From: Contact Centre (CRM) <contact@ribblevalley.gov.uk>
Sent: 29 May 2025 20:30
To: Planning
Subject: Planning Application Comments - 3/2025/0220 FS-Case-718712389

Planning Application Reference No.: 3/2025/0220

Address of Development: 4 West View
Grindleton
BB7 4RB

Job No - Dwg No - Rev  
**HA25001 - 03 - D**

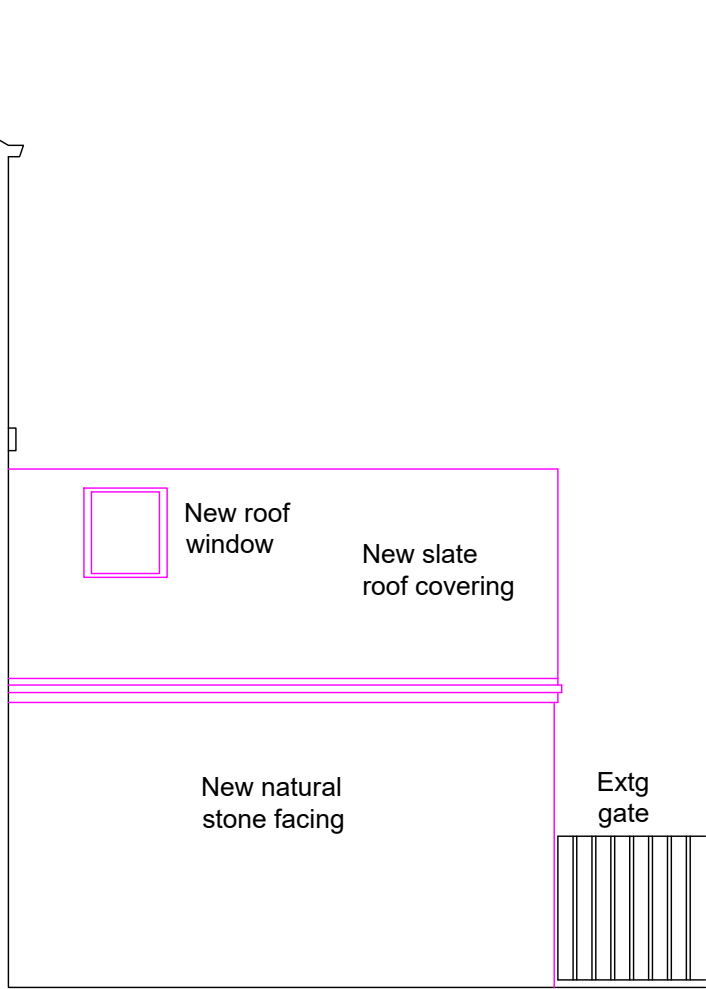
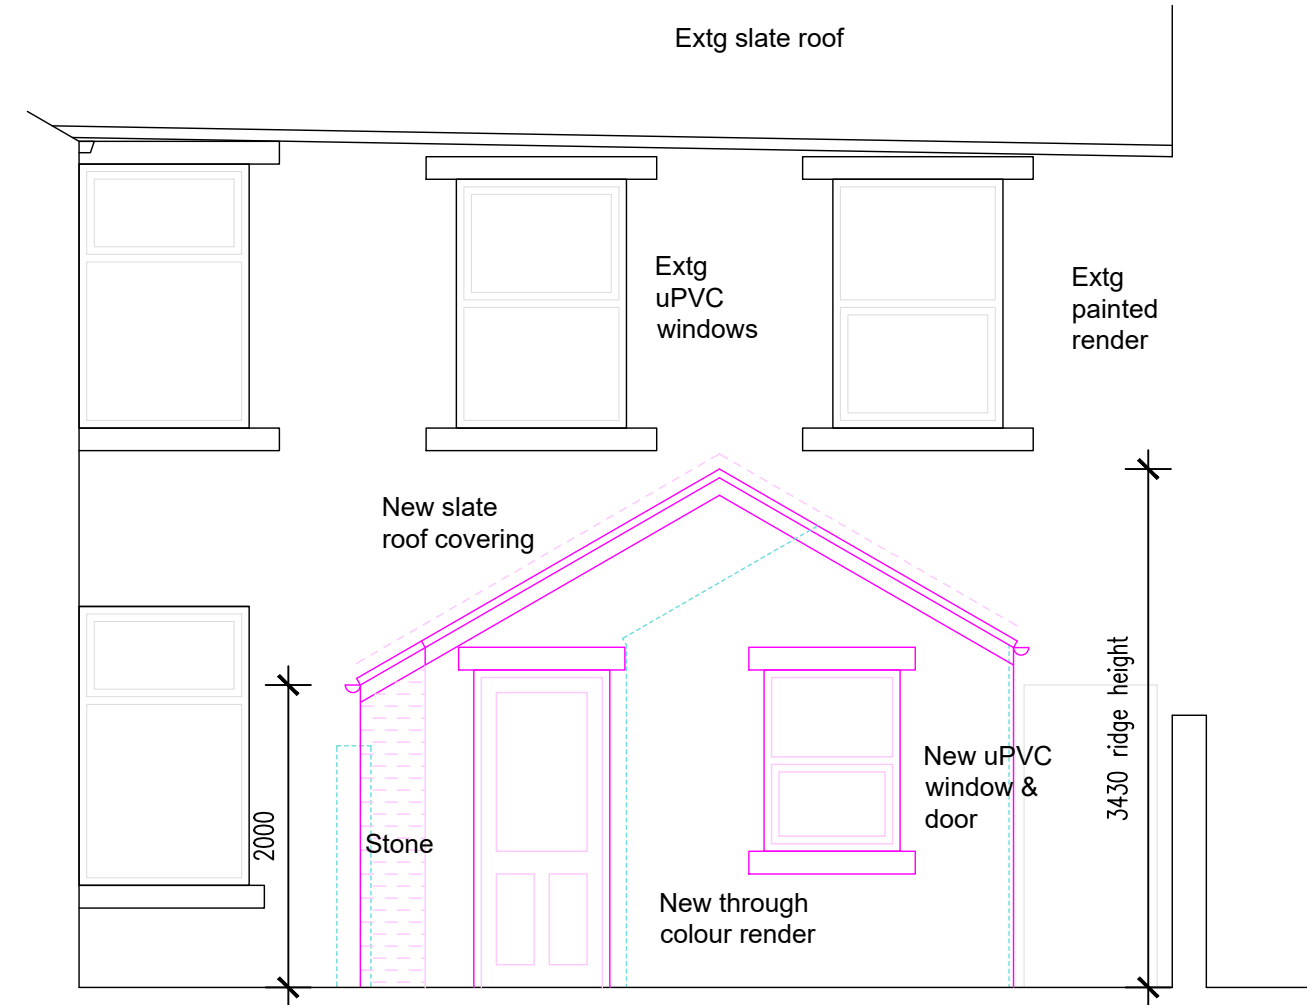
Comments: I've discussed with [REDACTED] and agreed that the [REDACTED]
[REDACTED], which doesn't appear to have been mentioned in the plans, or I may have missed it.
And I'm assuming that the extension wall will be no less than 50mm [REDACTED] as per
planning regulations.
I have no objections to the planning application, this is more for clarification.
Thank you.
